**Our reference:** R/2016/36/I

**Your reference:** SSD 6965 MOD 6

**Subject:** Barangaroo South – Building R4B – SSD 6965 MOD 6 – Advice on Modification

2.3 Level 1 Plant Room Separation Wall Added

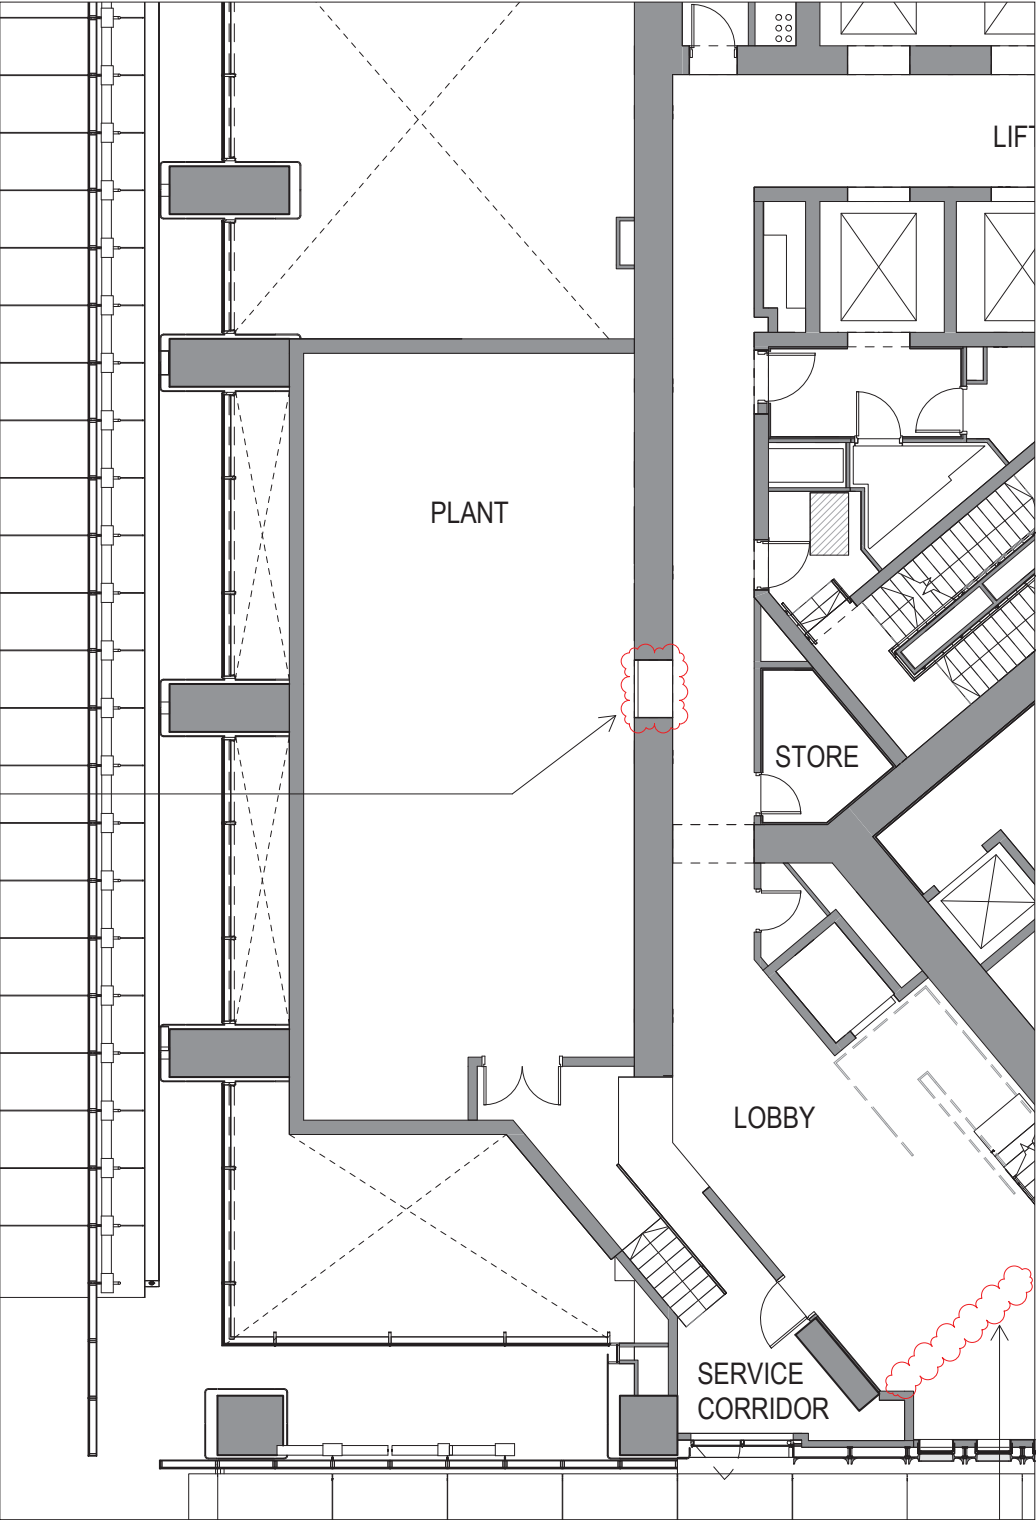
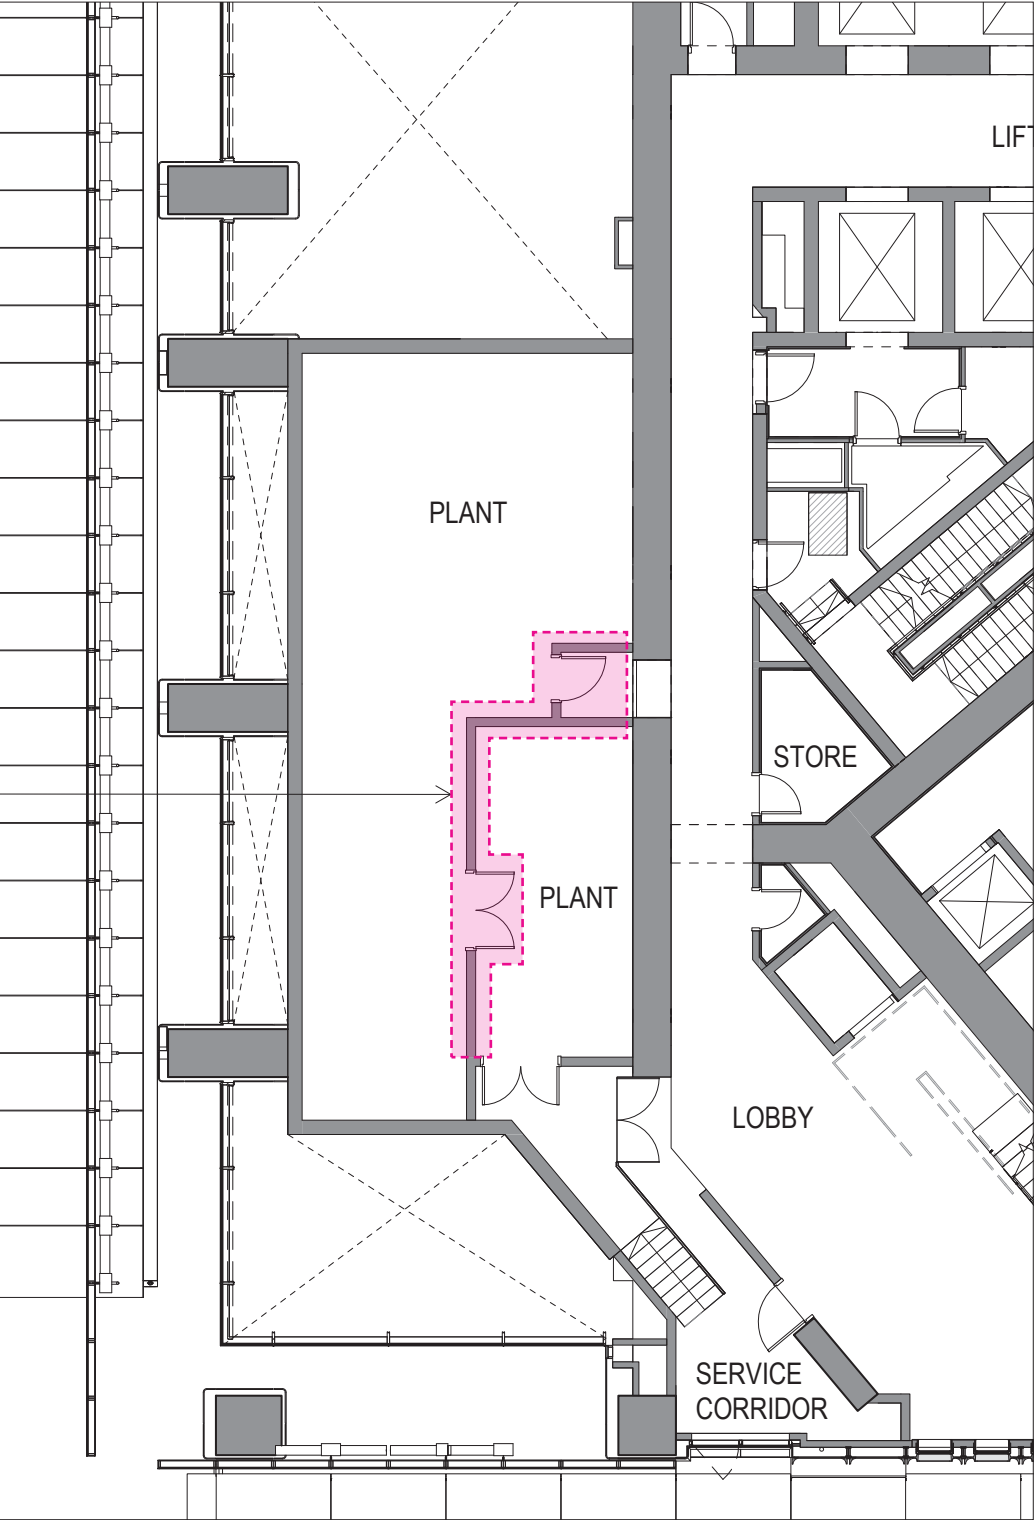
The City has reviewed the submission and does not raise an objection to the modification. The design modifications to the podium level plant rooms are minor in nature and are unlikely to impact the overall function of the development.
